From: Anita Gardner <Anita.Gardner@arun.gov.uk>
Sent: 21 July 2020 08:27
To: Planning.Responses <Planning.Responses@arun.gov.uk>
Subject: FW: AB/49/20/L Objection

Subject: RE: AB/49/20/L Objection

GROUND FLOOR PROPOSAL

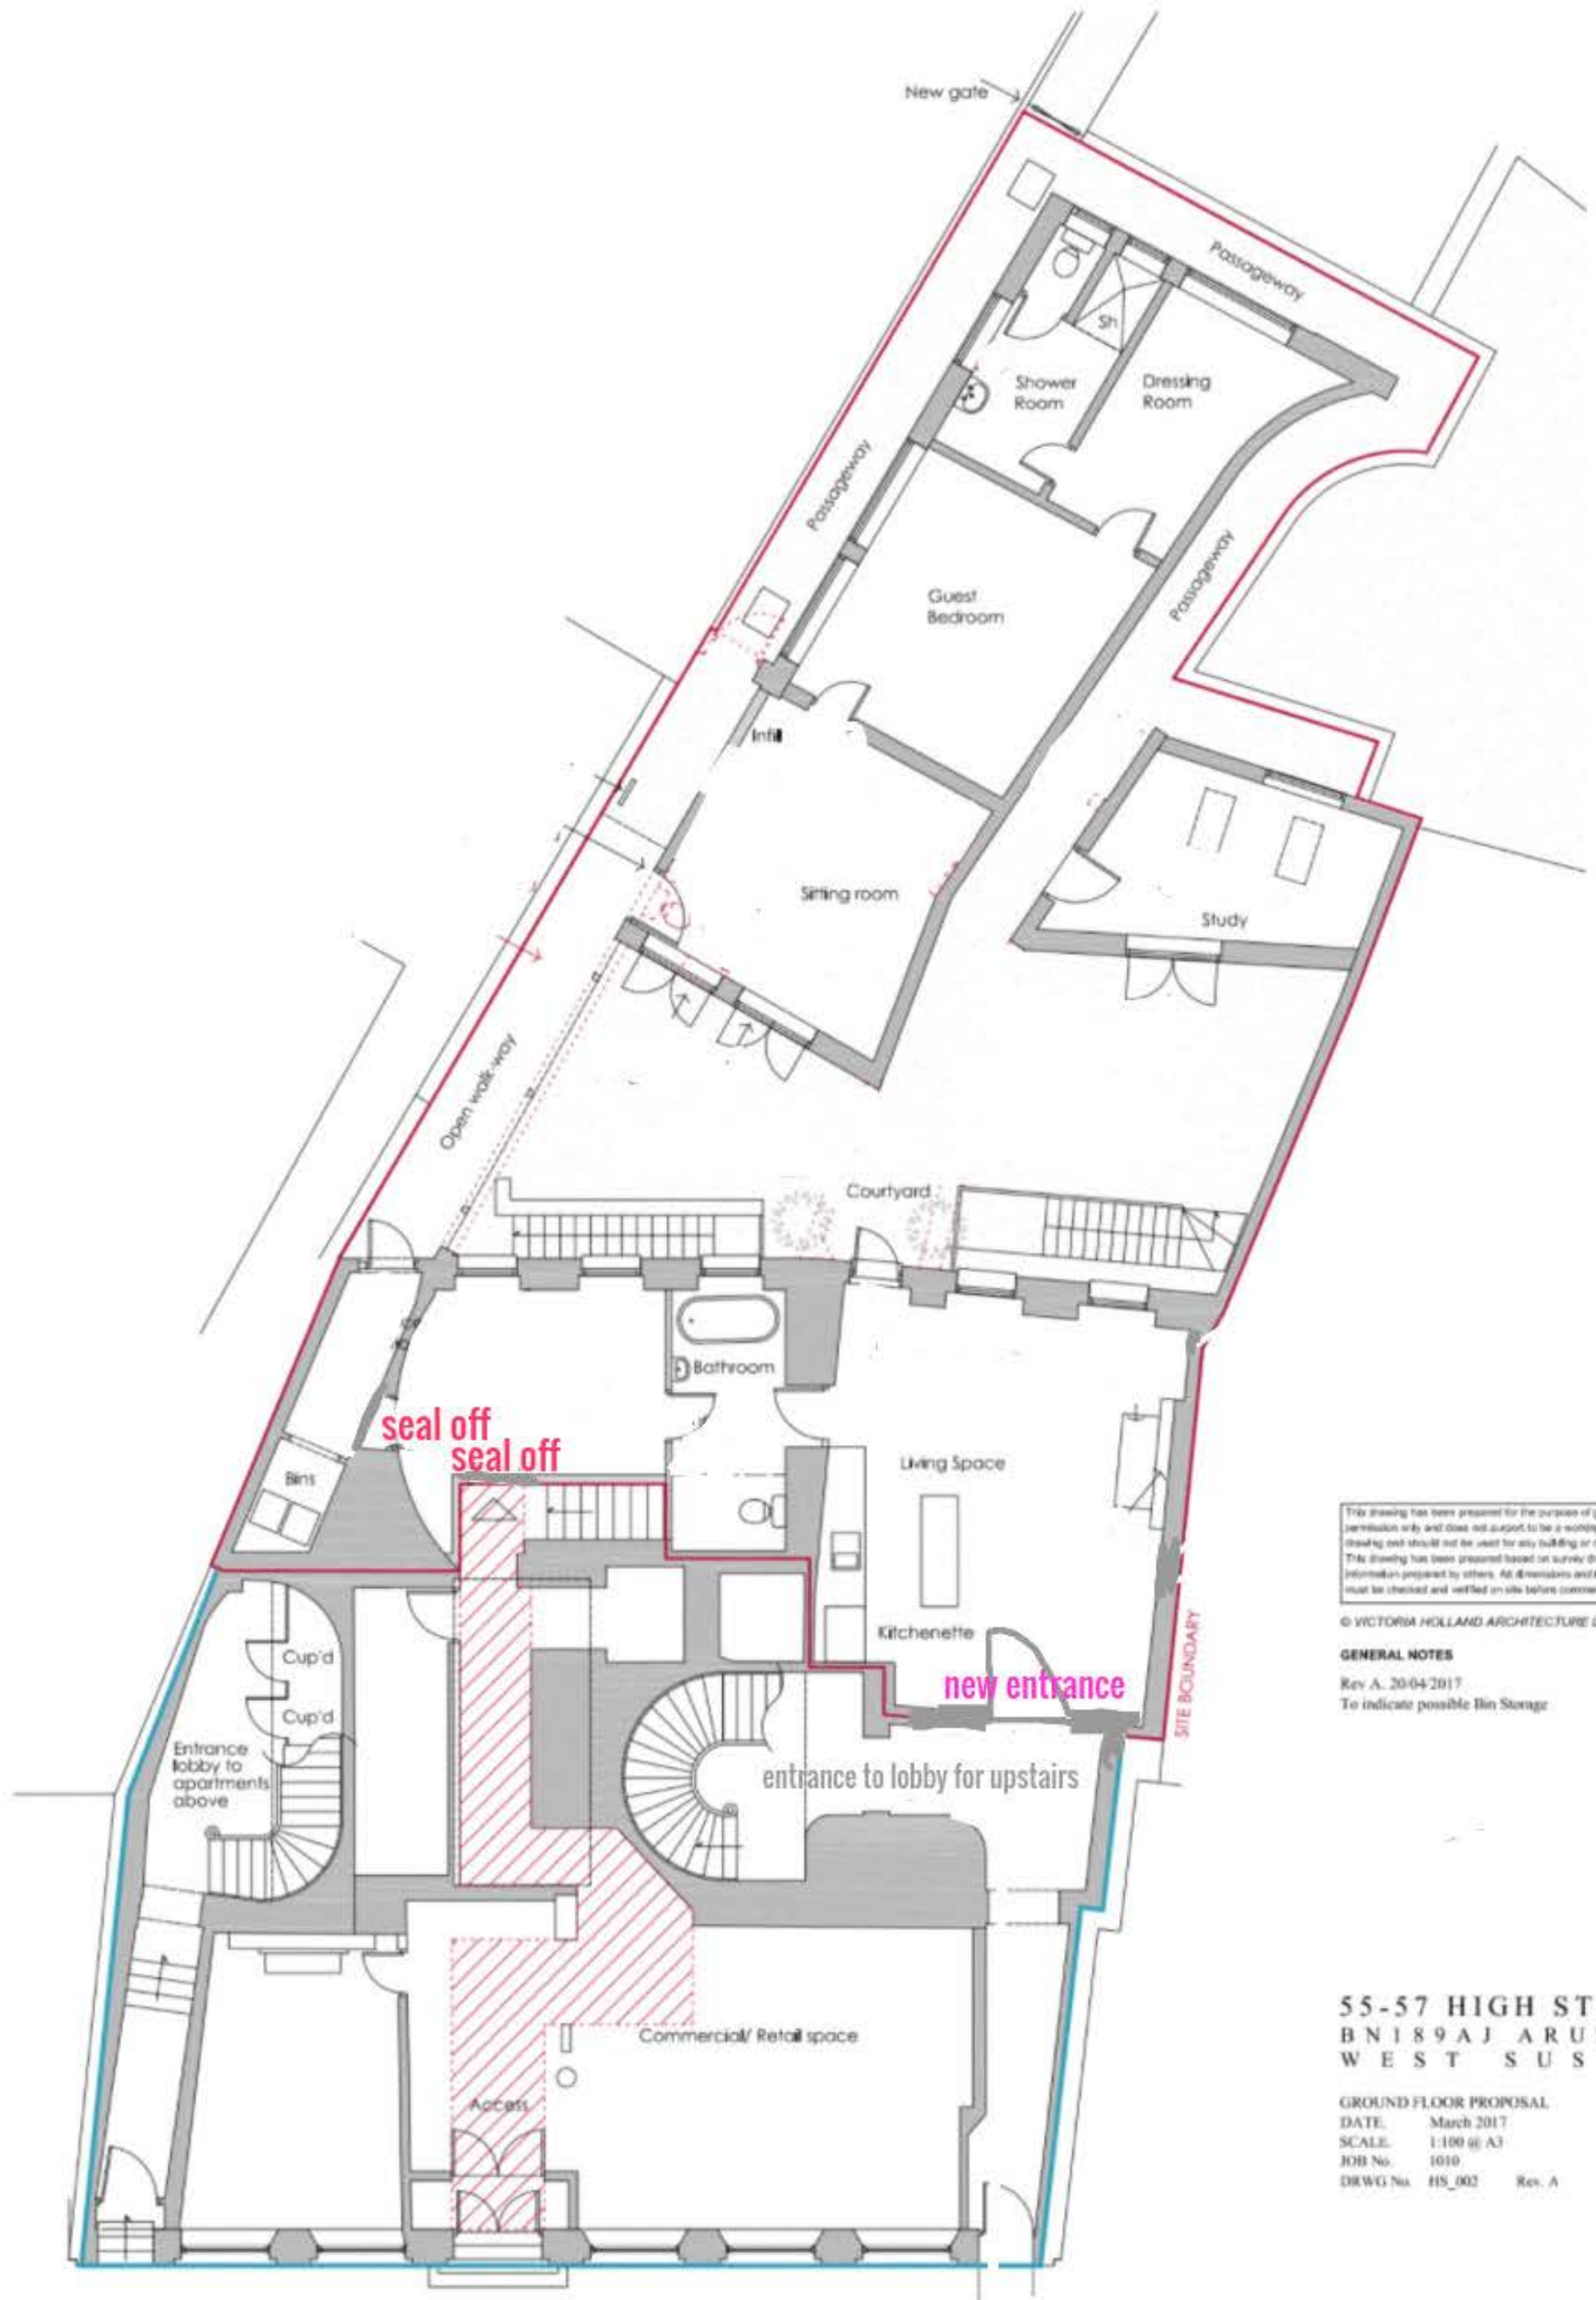
Further to my objection, I note that the new application AB/75/20/PL confirms in the proposed floor plan (attached) the 2nd entrance to flat 55B via the new entrance in the communal area of 55A that was already created without permission the week beginning 25th May 2020. The entrance is currently being used by both the applicant of AB/49/20/L and Paul Meredith. Additionally, note that if entrance 1 to 55B is blocked, then Digby Fine Wines (who is a licenced for alcohol) would no longer have fire escape access.

Proposed Ground Floor Plan
(Showing structure over)
(1:50)

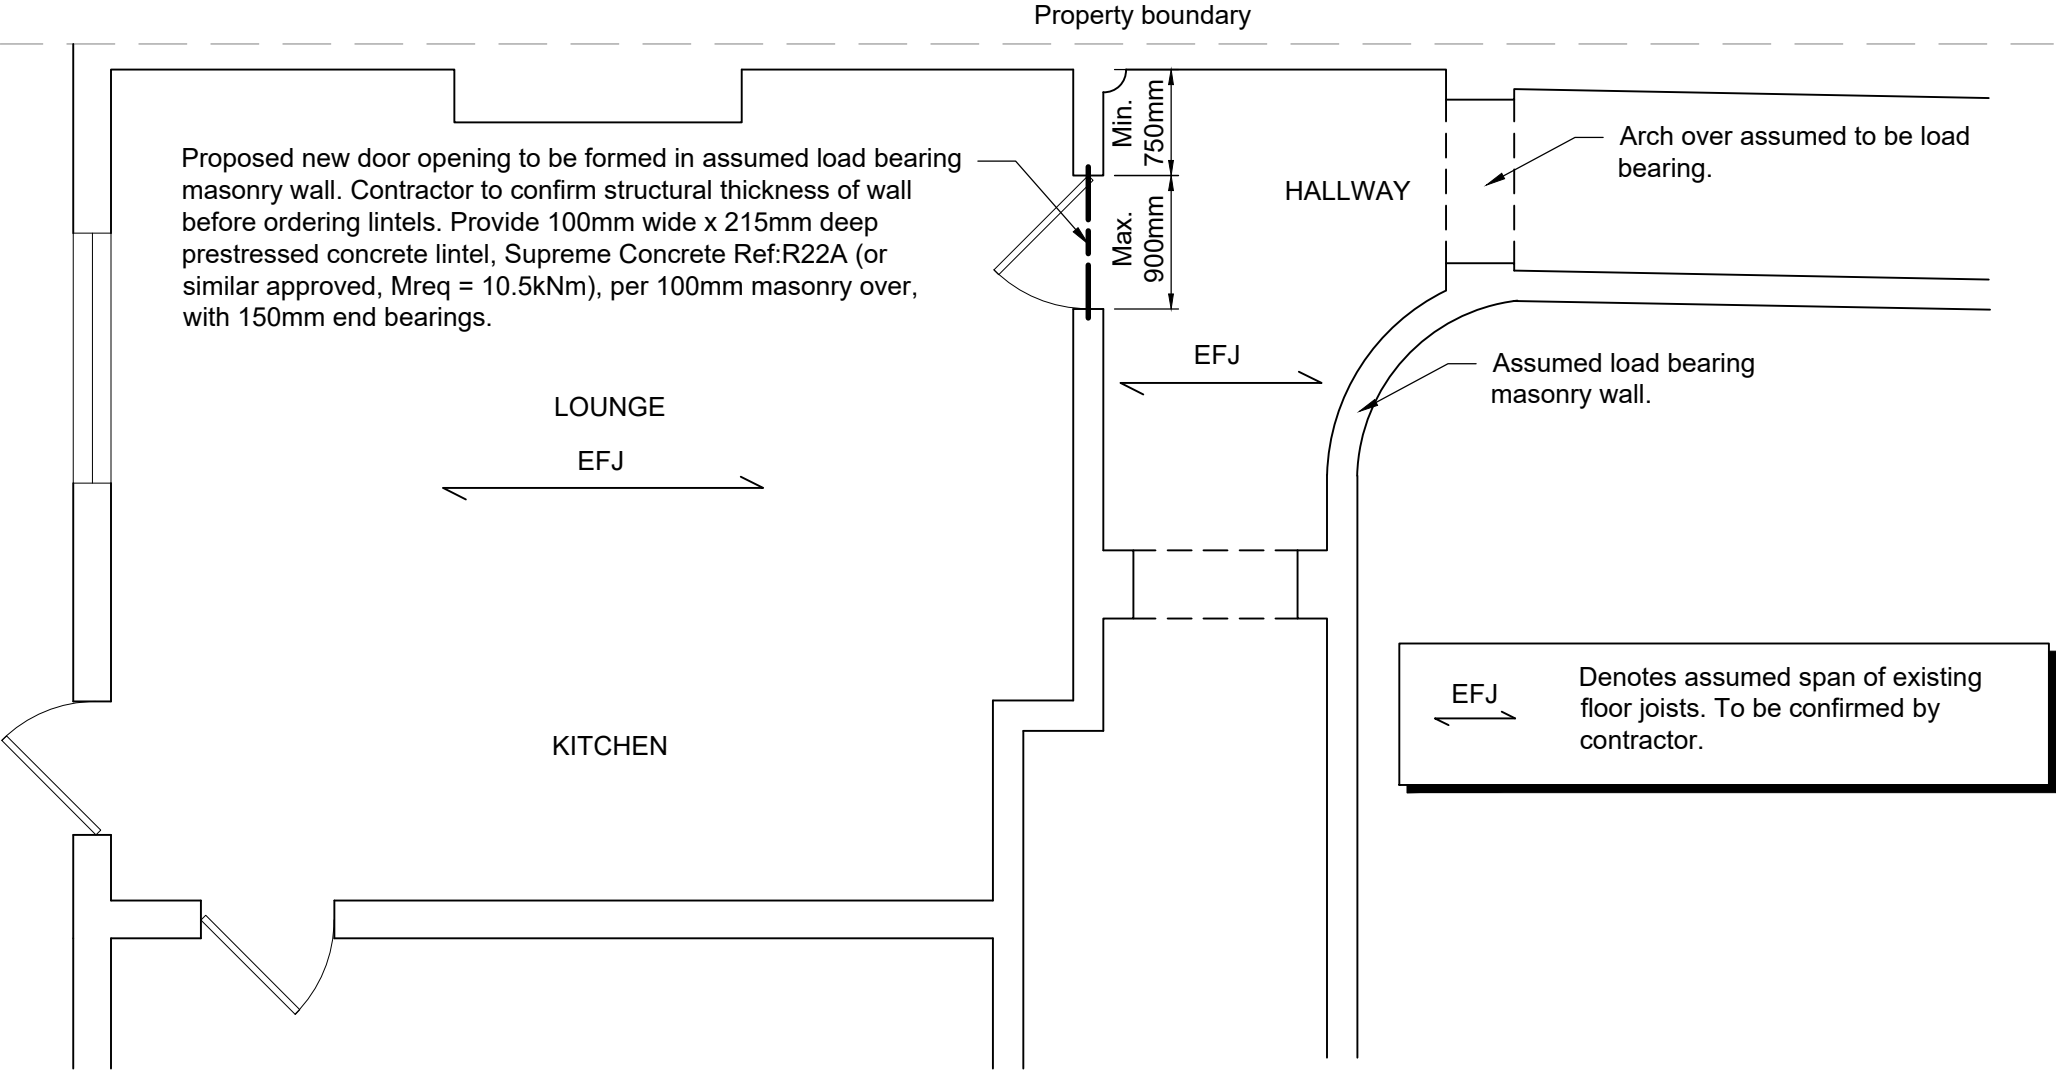
Therefore, until these issues are fully determined, it would be unwise to approve a **THIRD** entrance to flat 55B in the communal area at 57A **where the fabric of the building would be further compromised**. I also note that the oval staircase in the communal area at 57 is specifically mentioned in the listing <https://historicengland.org.uk/listing/the-list/list-entry/1247998>, any **unnecessary** new entrance would detract from this feature. Therefore the application should be rejected or in the very least the decision delayed until the status of the works at 55A is determined.

It is stated in their report that it is “conservatively assumed” that “the internal wall , where the new opening is proposed, is continuous from the ground floor up to the roof level.” **This assumption is incorrect.** The wall has already been knocked through at the first and second floors. Further, the structural engineer did not even attempt to notify me of his visit or make an appointment with me to view my flat or the flat above and has disregarded the works and issues that have occurred in the communal area of 55A (the same building). As a result, I have asked for a copy of their insurances but they have refused to provide these to me.
